DEVELOPMENT HEARING OFFICER

PR-2023-009498

SD-2024-00096

CSI – CARTESIAN SURVEYS INC. agent for LOE INVESTMENTS LLC requests the aforementioned action(s) for all or a portion of: LOTS 4 THRU 6, FRANCISCAN ACRES zoned MX-M, located at 2407 COMMERCIAL ST NE between MENAUL BLVD and PROSPECT AVE containing approximately 0.5274 acre(s). (H-14)

Plat for
Lot 4-A, Block 1
Franciscan Acres
Being Comprised of
Lot 4 thru 6, Block 1
Franciscan Acres
City of Albuquerque
Bernalillo County, New Mexico
February 2024

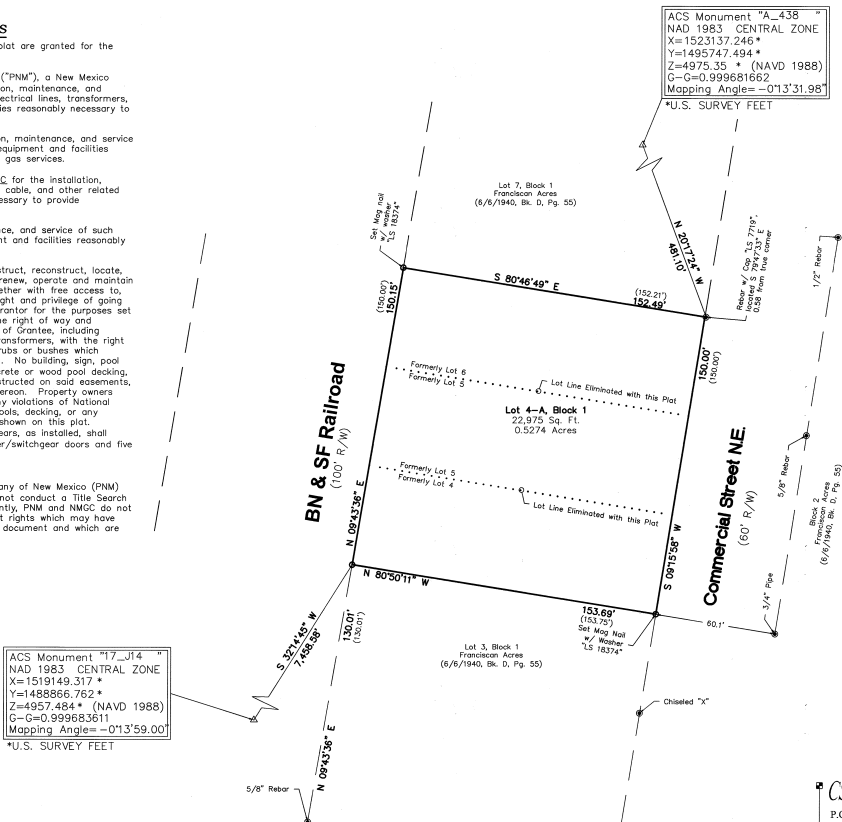
- Project and application numbers must be added to the Plat.
- Per 6-6(K)(2)(k) of the IDO, the date of the DHO approval shall be recorded on the original drawing of the final plat, and verification of compliance with conditions of approval shall be dated and verified by the signatures of the required commenting agencies pursuant to Subsection 14-16-6-4(J)(2).
- After DHO approval and final sign off, a recorded copy of the plat must be sent to the Planning Manager-Jay Rodenbeck and PLNDRS@cabq.gov (should the Plat be approved by the DHO).
- ***If Major infrastructure is needed, an IL-Infrastructure list, and/or IIA-Infrastructure Improvements Agreement with financial guarantee will be required. Please confirm if any infrastructure improvements are required.***
